**Council Reference:**  
**Your Reference: SSD8169 & MP09\_0028 Mod 5**

10 October 2018

**Tweed Shire Council comments on the proposed North Byron  
Parklands Cultural Event Site (SSD 8169) and modification of  
the Concept Plan (MP09\_0028 Mod 5)**

LOCALITY PLAN
NOT TO SCALE

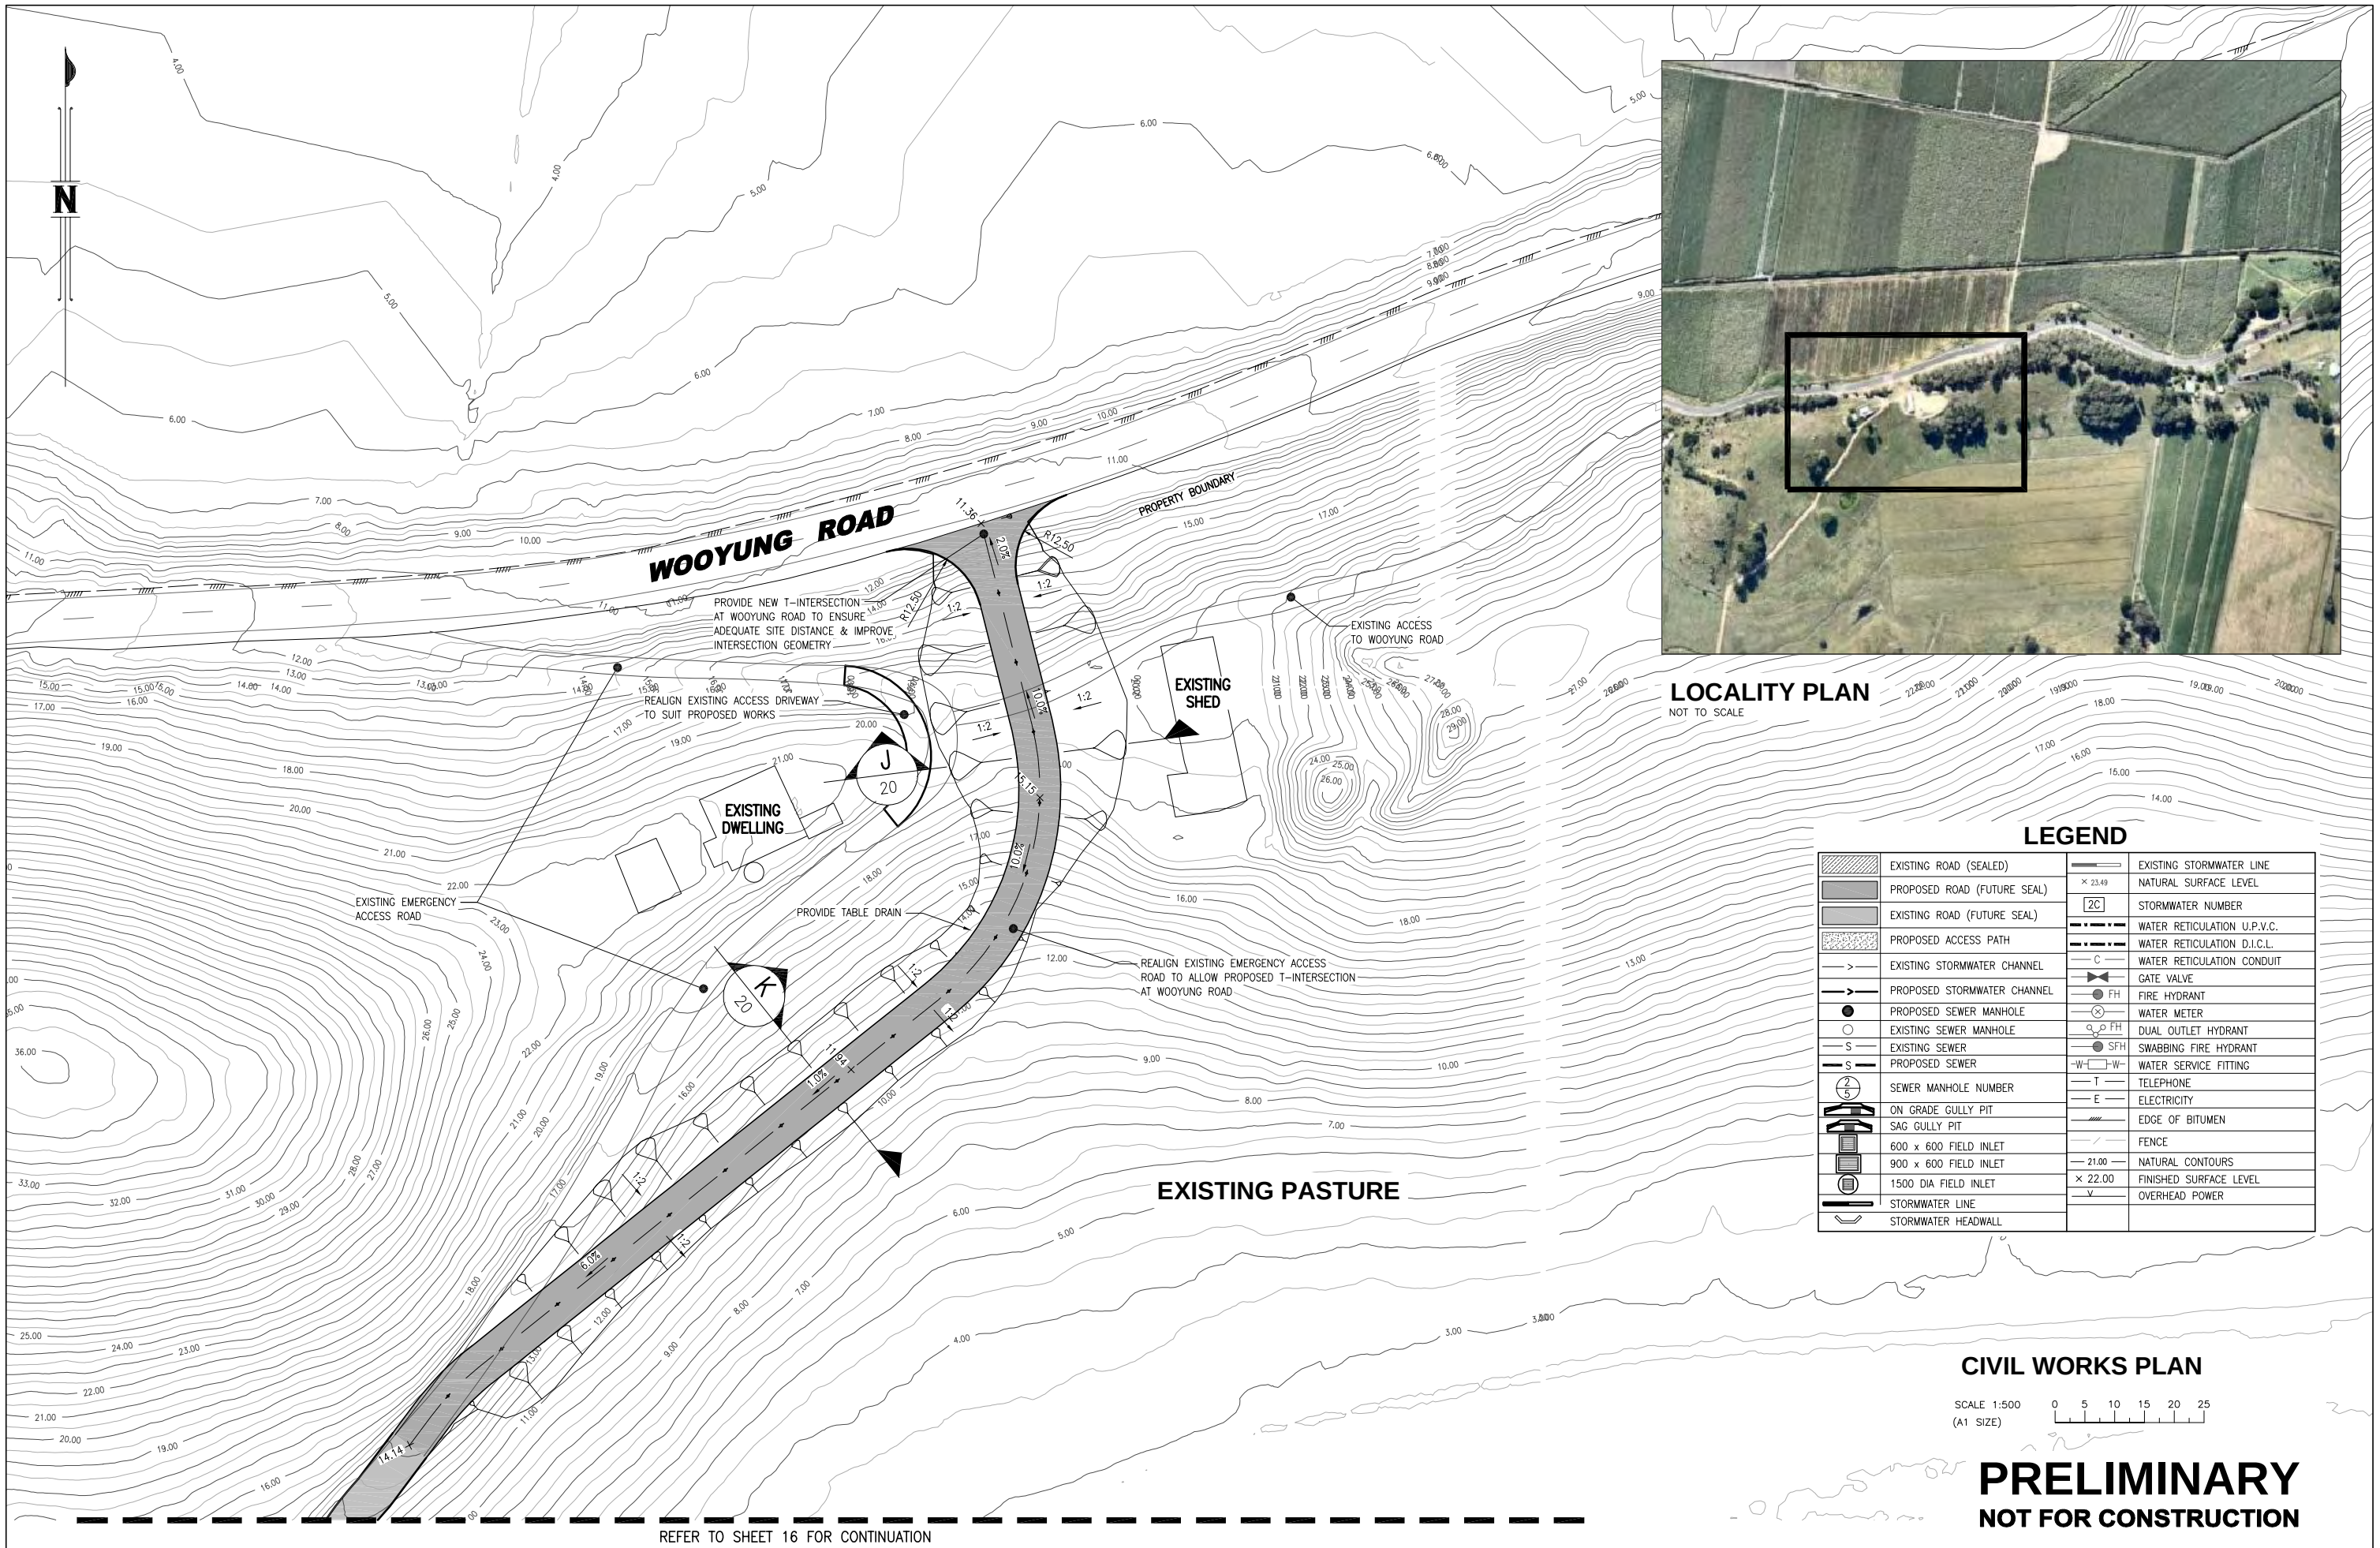
- a. The preliminary design for the new access to Wooyung Road (shown on Page 2 of *Appendix A - Revised Civil Design Plans*) identifies that fill may be required on adjacent private property, not the subject of this application.

Whilst the design is preliminary, it is recommended that a suitable condition be applied as noted below.

***Subject to the submission and approval from Tweed Shire Council through s138 Roads Act 1993, the proposed access and associated road widening is to be constructed wholly within Wooyung Road and designed to the Austroads Guides to Road Design for a BAR/BAL intersection and to Council's DCP Section A5 Subdivision Manual D1 Road Design.***
